Subject: FW: BN/18/20/PL, Former Brooks Nursery

Please Upload the below and attached to the above application: additional information(drainage)

In terms of the proposals effect on the existing suds (surface water drainage system), I would like to make the following comments;

A	21.05.19	Bellmouth amended	HJS
REV. No.	DATE	DESCRIPTION	INITIALS
Client	 BARRATT HOMES		
Project	Brooks Nursery Barnham		
Title	Foul Outfall Rising Main Details		
Scale	1:250	Date	Sept '18
Checked	AMc	Drawn	AMc
Drawing No.	4482:510	Rev	A

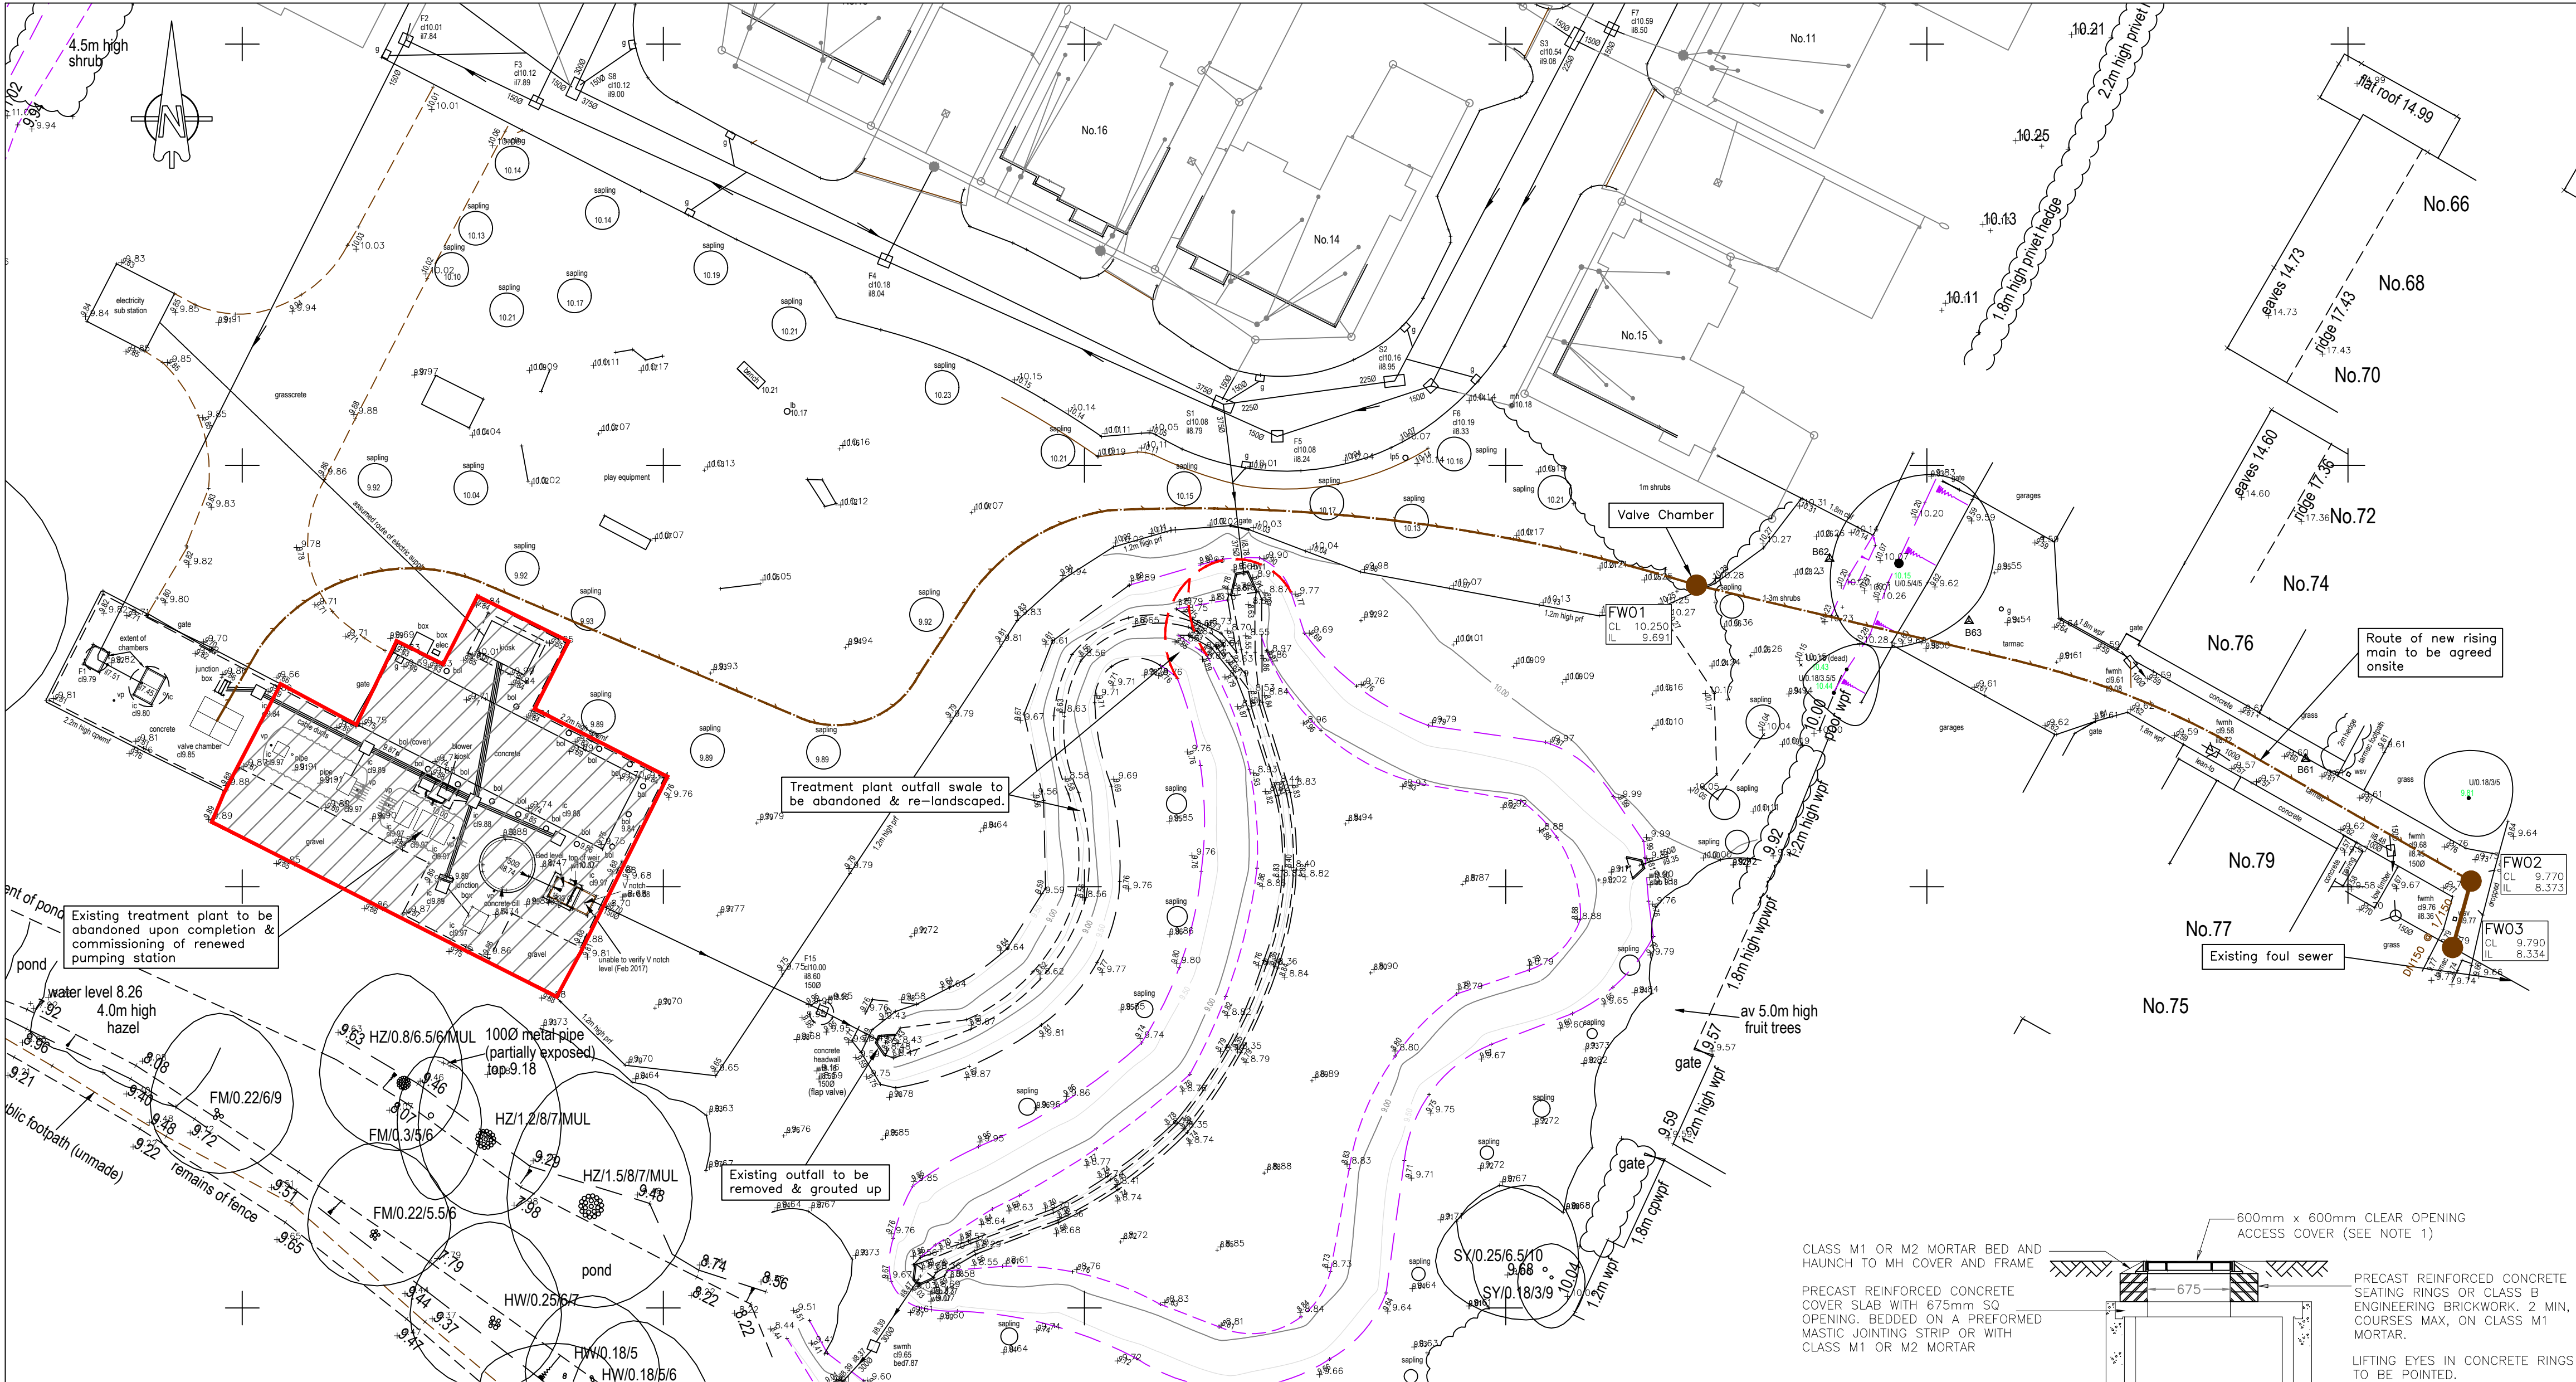
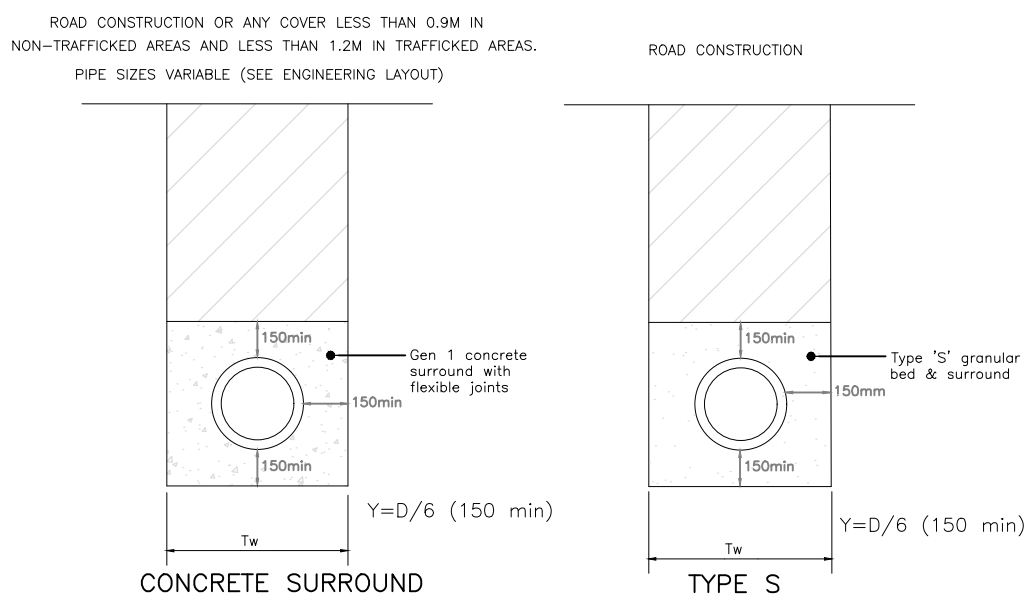
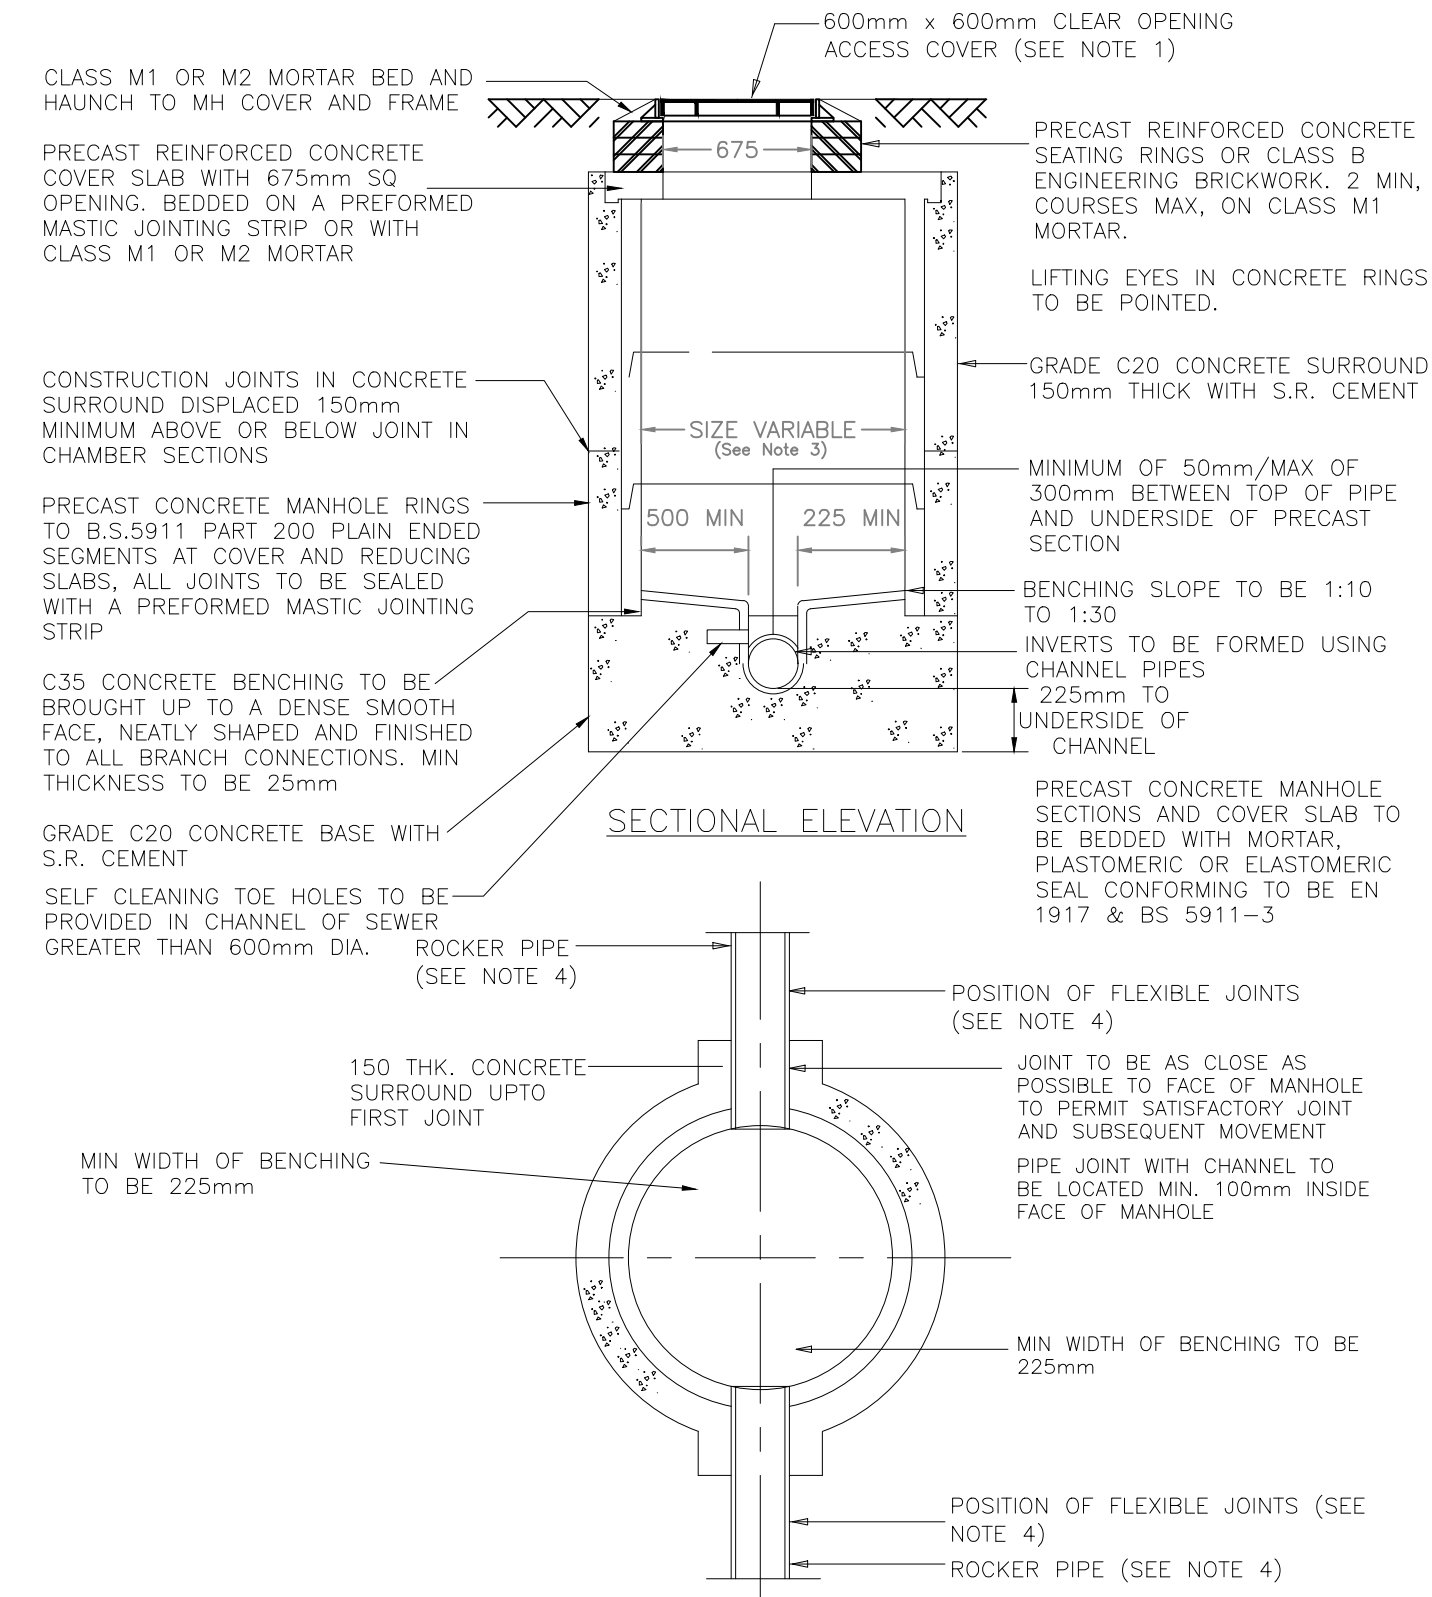
- a) The open channel/ditch in which the sewage treatment plant discharges into at present, before it connects into the suds pond, is proposed to be infilled.
The applicant will need to provide written confirmation with supporting calculations to prove that the storage for surface water within the suds system is not compromised as a result.
- b) Where the proposed rising crosses the incoming surface water outfall to the pond and the known land drain running parallel to the eastern boundary of the development, the applicant should provide a longitudinal section to prove no impact on these pipelines.

Finally, the long section requested was already shown on drawing no, 4482.510A , which I attach for reference along with the other engineers drawings which were agreed at the meeting
